13 January, 2022

Our ref: 21/29

Your ref: MP10_0108-Mod-1

**RE: SHOALHAVEN STARCHES – GAS PIPELINE (MP10_0108-MOD 1)
RESPONSE TO REQUEST FOR ADDITIONAL INFORMATION FROM DPIE - WATER**

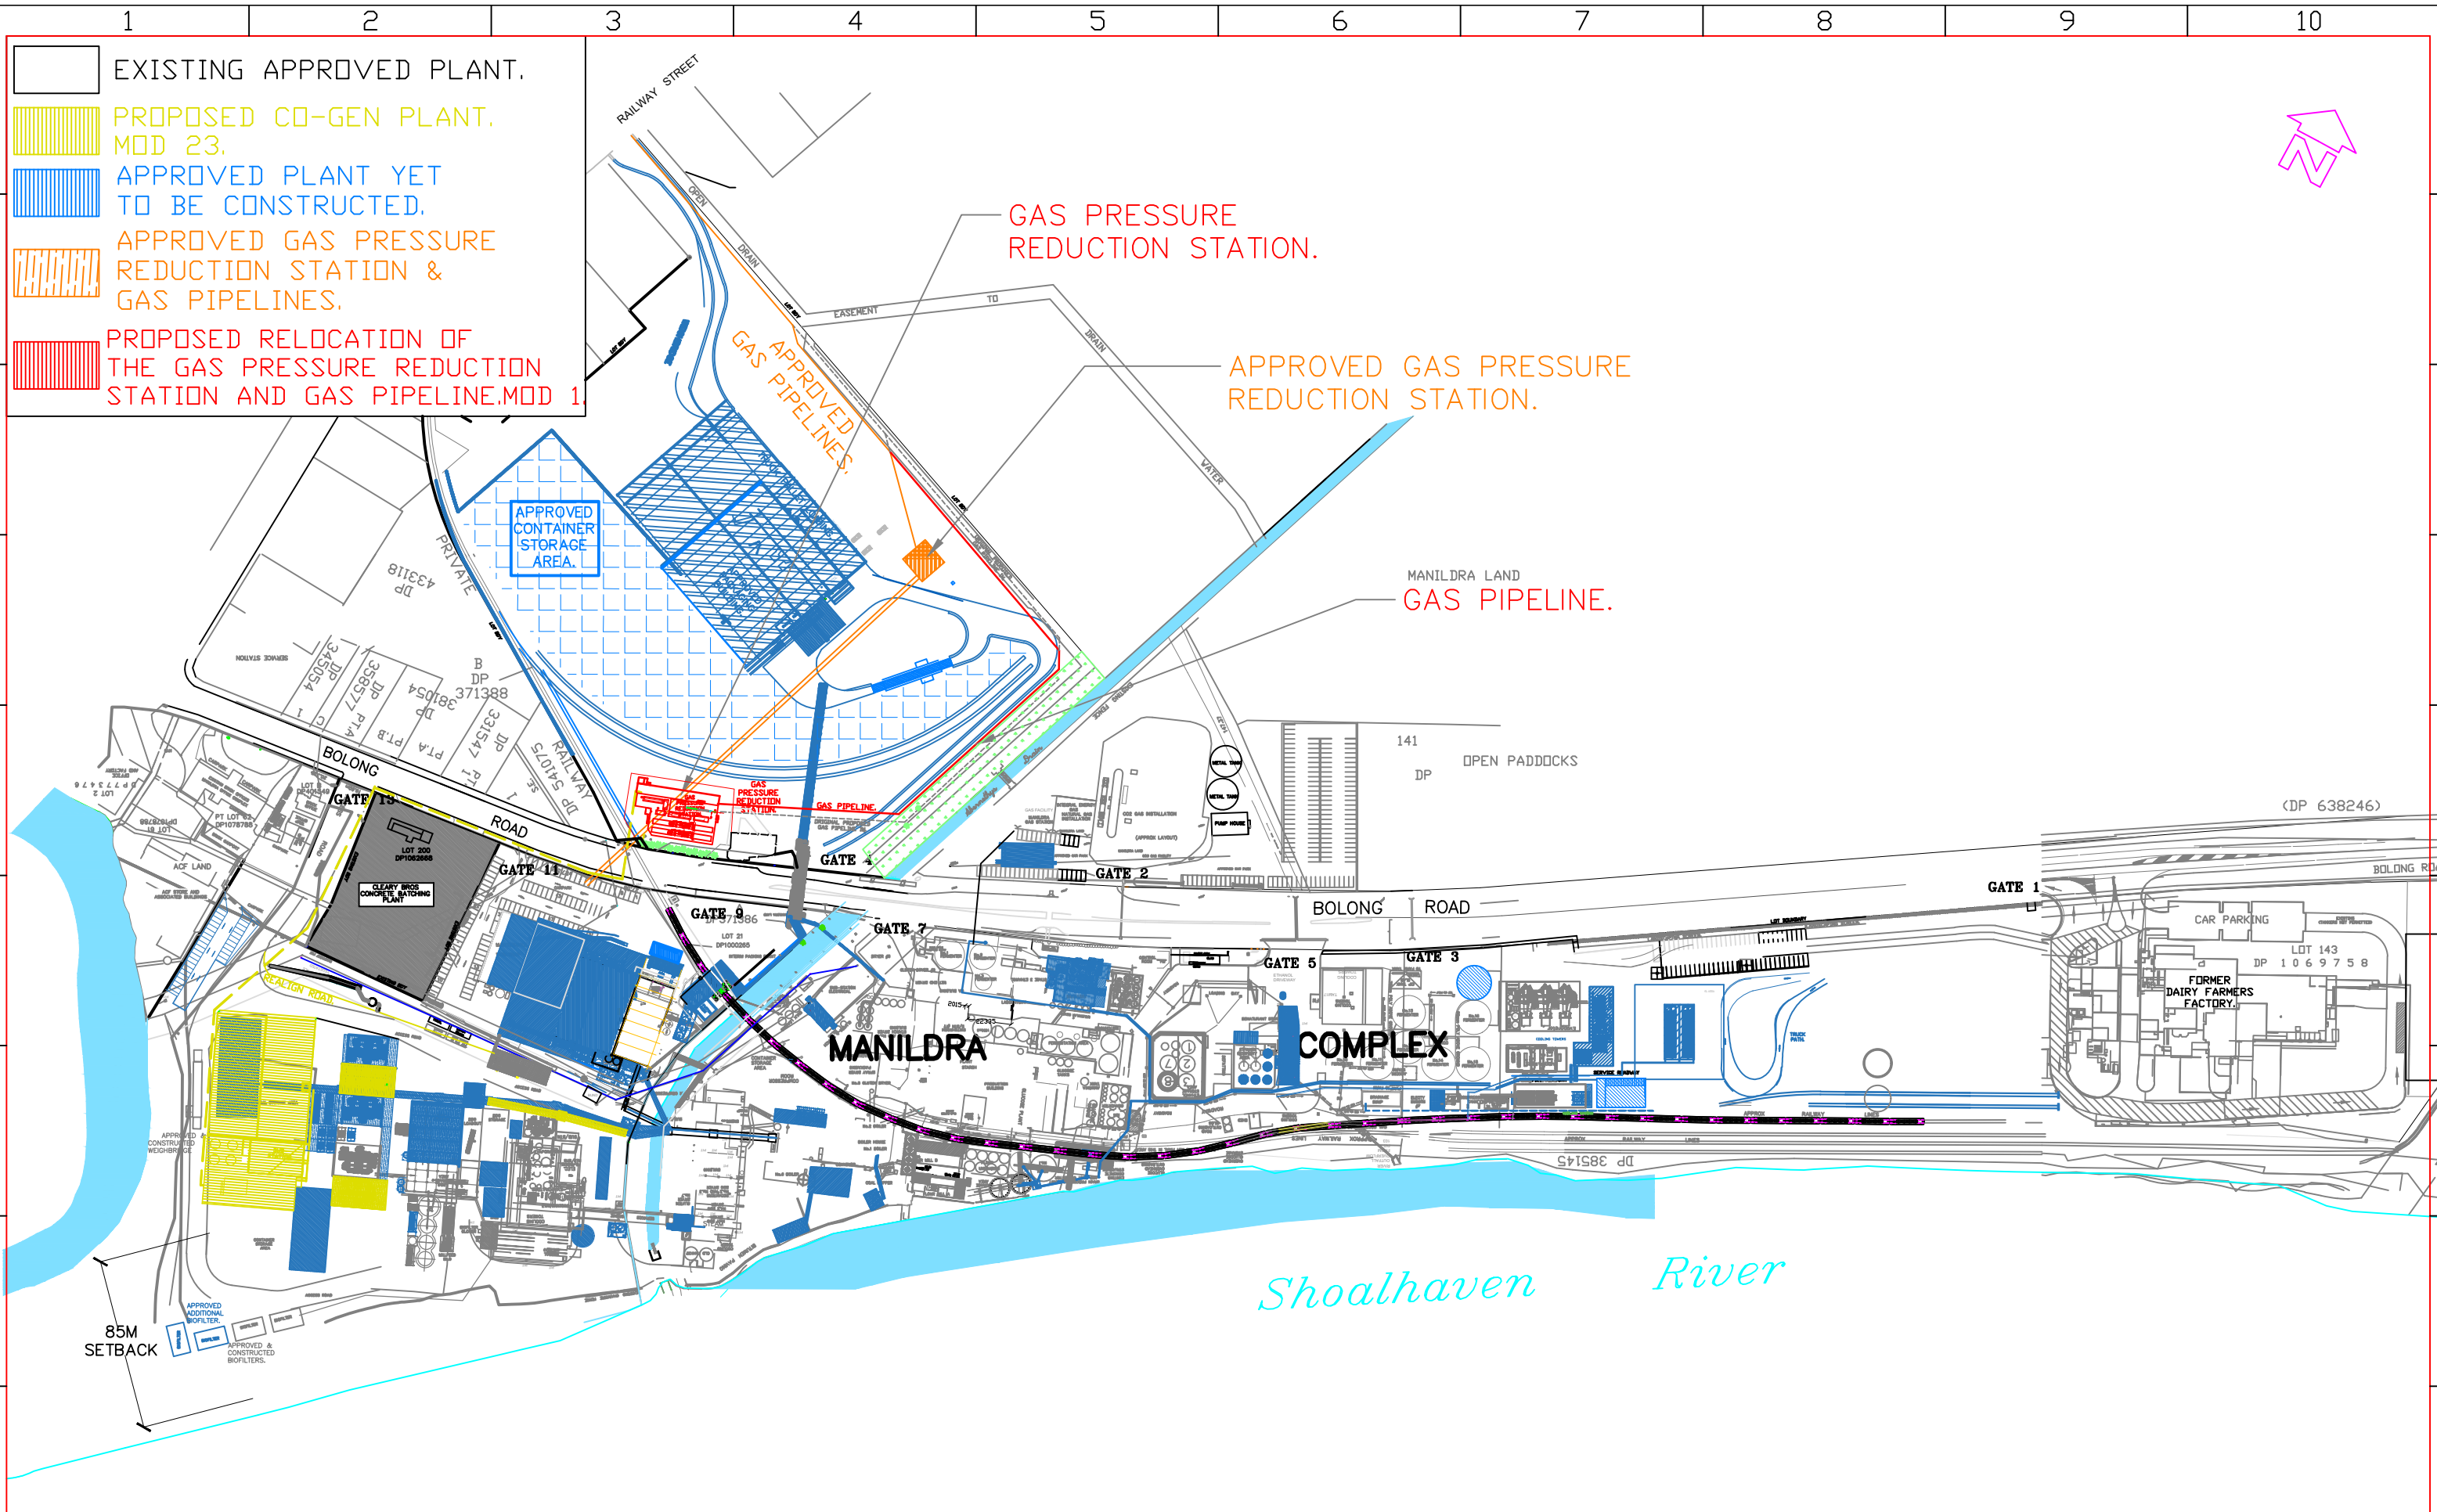
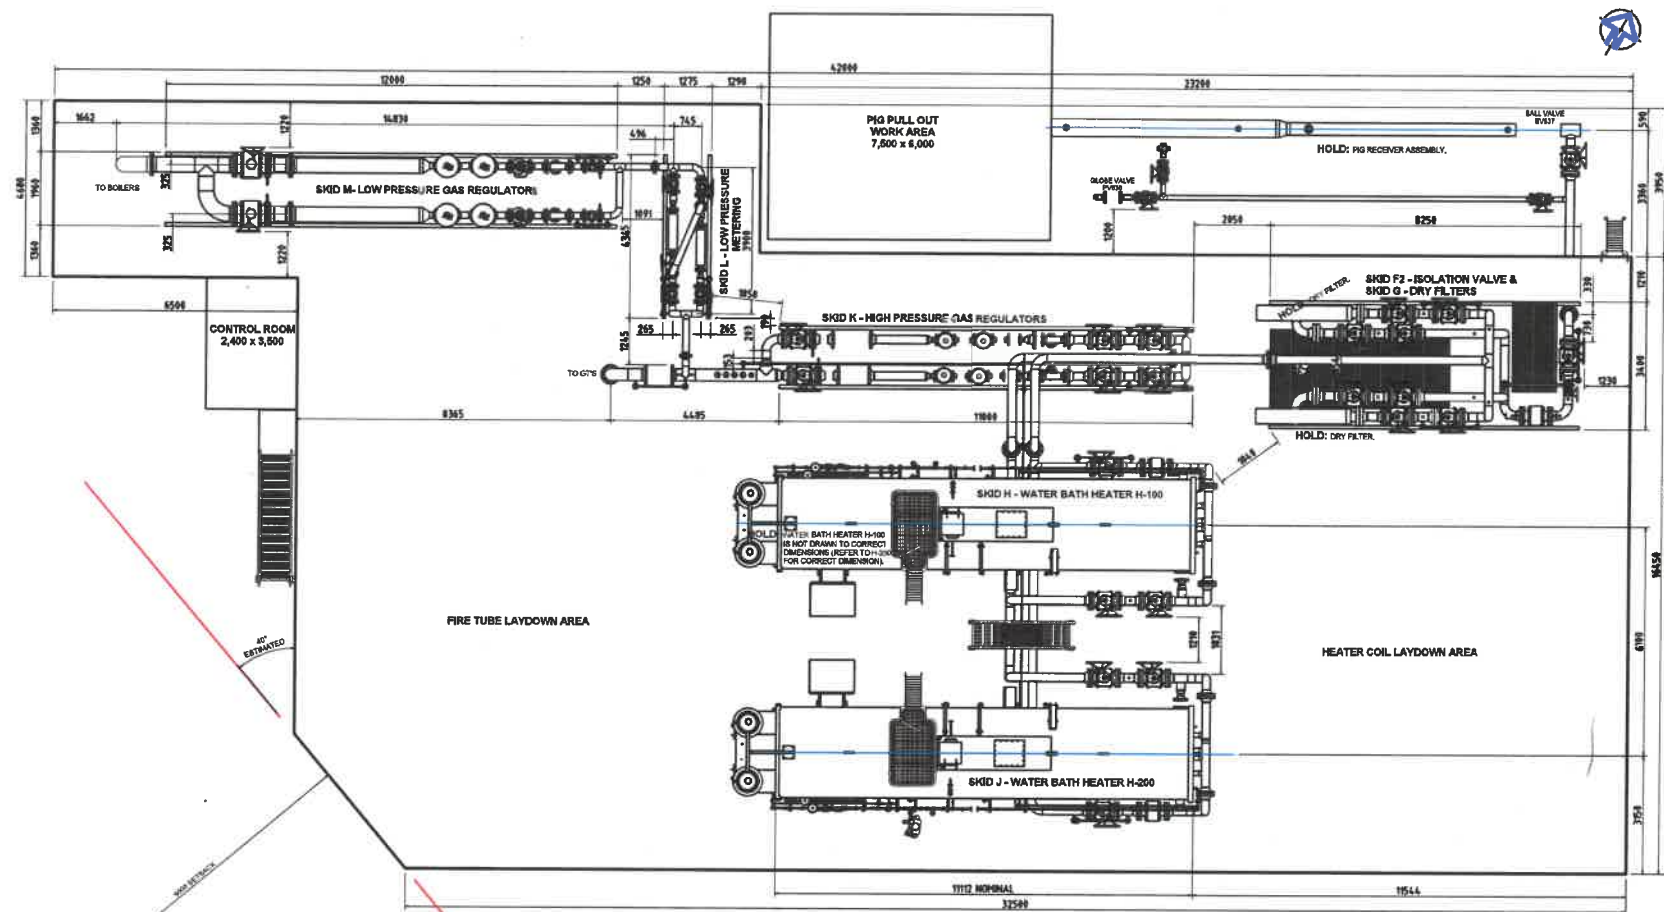
- provide details of excavation works including width of the trench for the pipeline on waterfront land of Abernethy's Creek.*
- provide details on how the proposed pipeline realignment is in accordance with the Guidelines for Controlled Activities on Waterfront Land (NRAR 2018) as works are encroaching within the riparian zone.*

Manildra has now amended the Mod 1 plans to re-locate the gas pipeline to 19 m from the western bank of Abernethy's Creek, outside of the approved 18 m riparian re-vegetation area along Abernethy's Creek. The trench depth will be a maximum of 1 m and trench width will be less than 0.5 m.

Please also find attached a revised drawing set for this Modification Proposal showing the relocation of the proposed pipeline alignment now setback back 19 metres from the bank of Abernethy's Creek and therefore outside the approved 18 metres setback to this creek.
